**Albuquerque Studios Master Plan
Development**

Traffic Impact Study

October 13, 2021

The following two sections in the Executive Summary list agency comments received on the draft TIS submission along with responses provided for this final TIS.

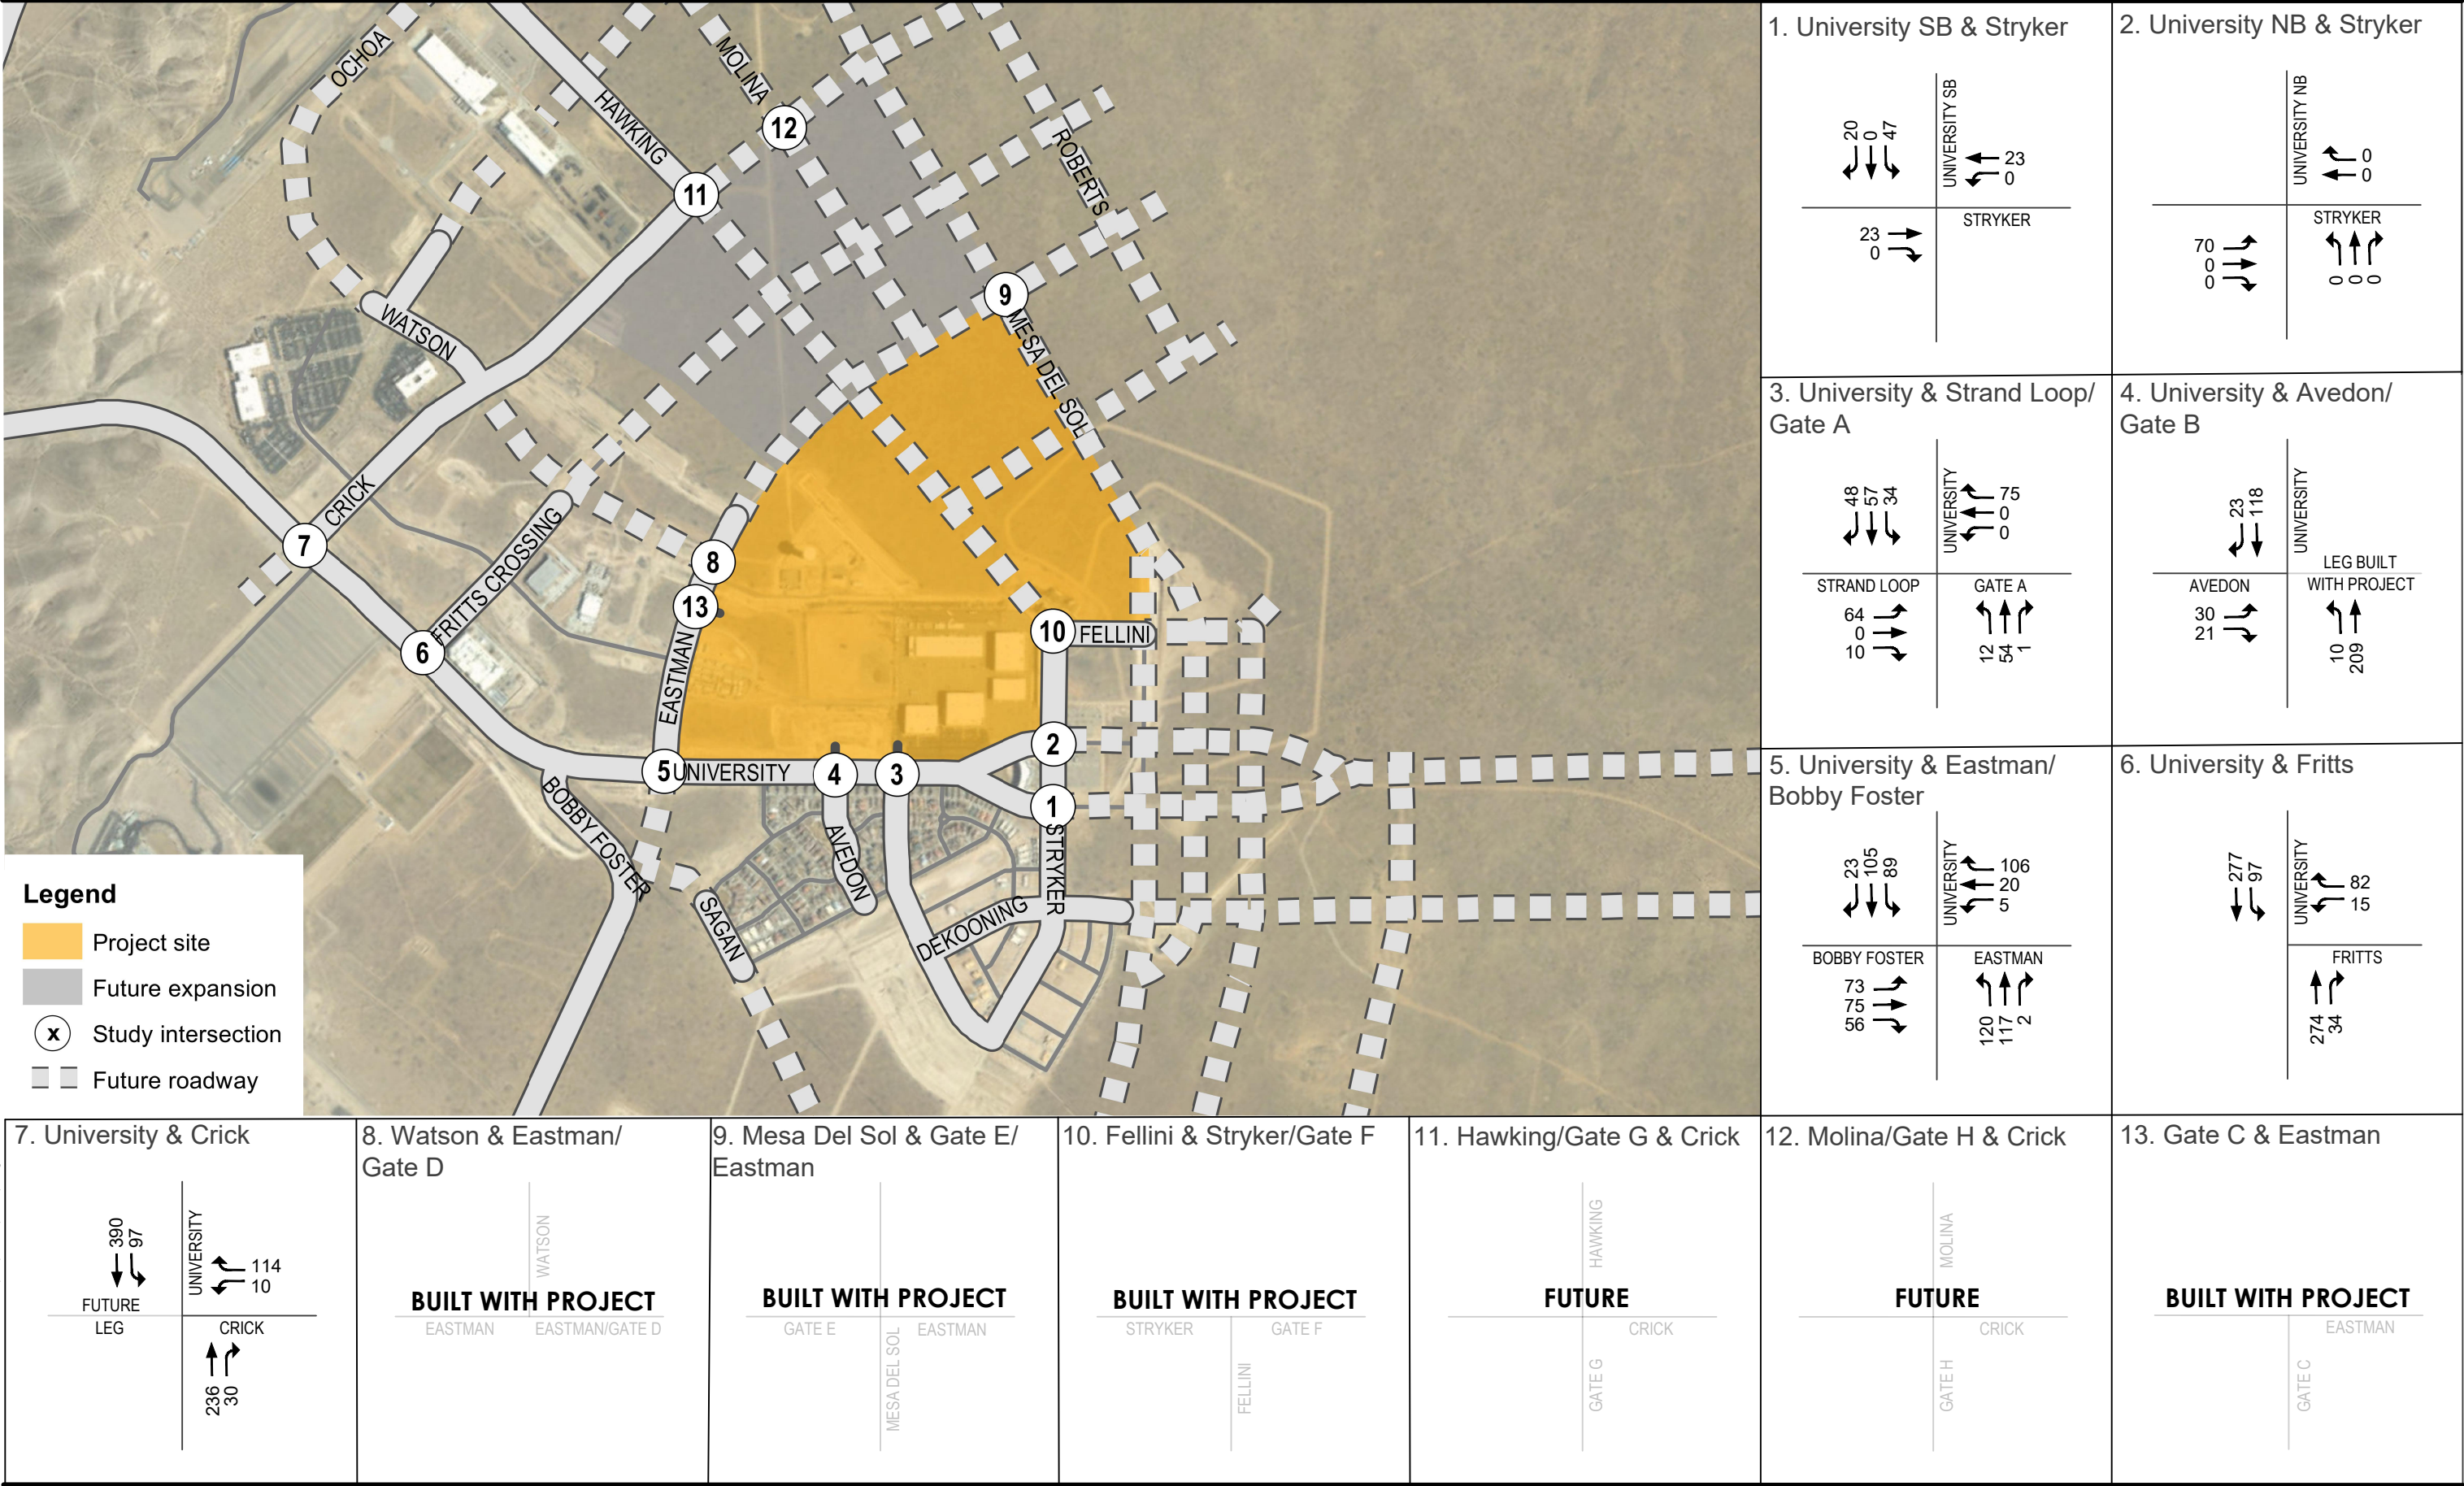
2. The trip distribution on Bobby Fosters Rd. is higher than expected. The Netflix buildout year traffic in the AM peak is 1,016 vehicles per hour (vph) eastbound and 218 vph westbound. The PM peak has 671 vph eastbound and the westbound direction has 1,523 vph. Bobby Foster does not have an interchange. The Mesa del Sol master plan committed to building the Mesa del Sol interchange. A majority of the Bobby Foster traffic should be shifted to University Blvd. As University Blvd. nears capacity the excess traffic should shifted to Mesa del Sol Blvd.

3. Provide a justification for the amount of traffic on Bobby Foster. The level of service will need to be evaluated for Bobby Foster.

This TIS used Trip Generation estimates provided by others for Montage for contributing traffic on Bobby Foster. ½ of the Montage development traffic was

forecasted to use Bobby Foster toward University. Of that, 70% was assigned to University/Bobby Foster and 15% each to Avedon/University and Strand Loop/University.

The traffic analyses conducted on Bobby Foster included access to and from the Montage Development. A review of the preliminary site plan was used to estimate the traffic described above for Bobby Foster. An LOS analysis was conducted for Bobby Foster/University and Eastman that included the traffic forecasts. The LOS is for Bobby Foster and University is forecasted at LOS B for the Implementation Year (2026) for both AM Peak Hour and PM Peak Hour (TIS, Pg. 28). The intersection is forecasted to be LOS D (for both AM and PM Peak Hour) for the Horizon Year Analysis Period (Level B Master Plan) (TIS Pg. 29).

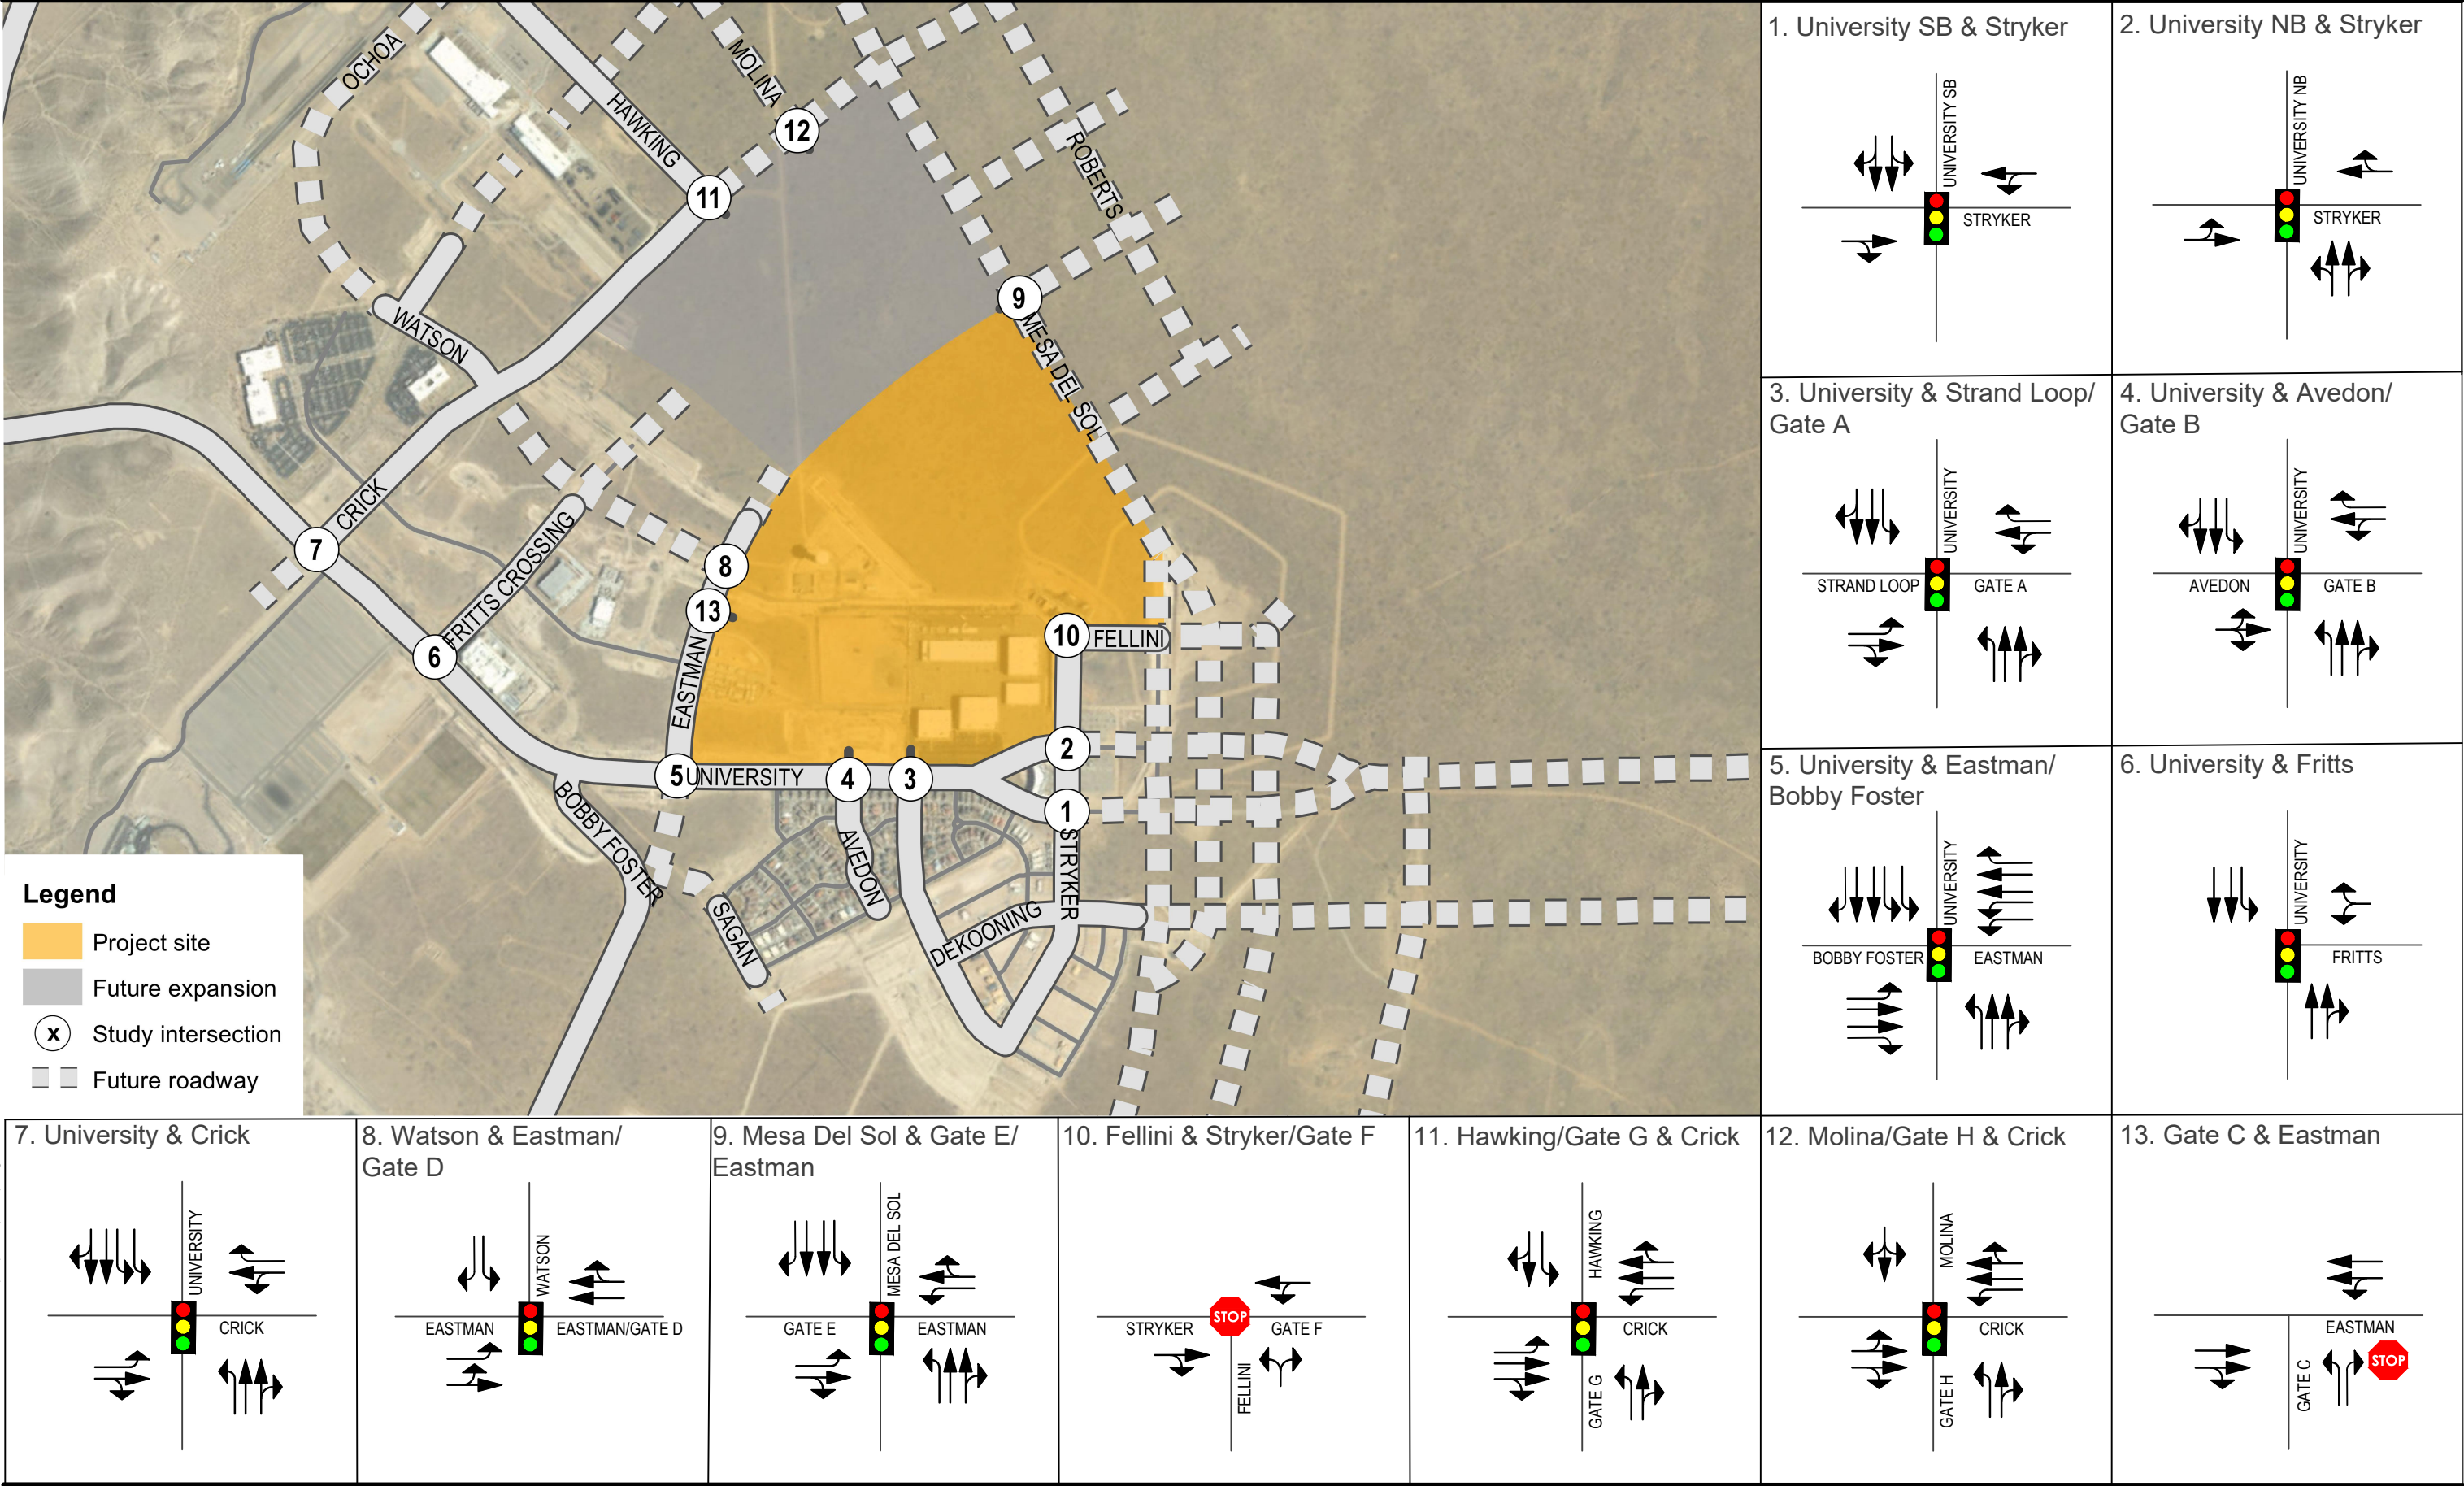
8. If a traffic signal at University Blvd. and Crick Ave. or other intersection are anticipated a traffic signal warrant will need to be conducted. Alternative intersection control should be considered along with the traffic signals.

There are recommendations for signalized intersection at the following intersections in future years. Could any of these be a modern roundabout?

University and Eastman (#5).

University Blvd and Crick (#7)

University Blvd and Crick Ave. was analyzed in the study. This intersection is recommended for Two-Way-Stop-Control (TWSC) for the implementation year and for a traffic signal for the horizon year, assuming continued growth consistent with the Level B Master Plan.

Modern Roundabout Analysis: This intersection could potentially operate at an acceptable LOS as a roundabout. It is recommended that it be re-considered in the TIS conducted for the Athletic Complex improvements once traffic projections are forecasted for this development. There are several considerations such as special event traffic and peak hour traffic scenarios for consideration. Impacts to adjacent corners of the intersection and geometric footprint of the roundabout should be considered in the decision to proceed with a roundabout traffic control type.

A Signal Warrant Analysis (SWA) was conducted for future conditions (Implementation Year). The applicable warrants 1,2,3 (8-hour,4-hour, and Peak Hour) were not satisfied for the intersection.
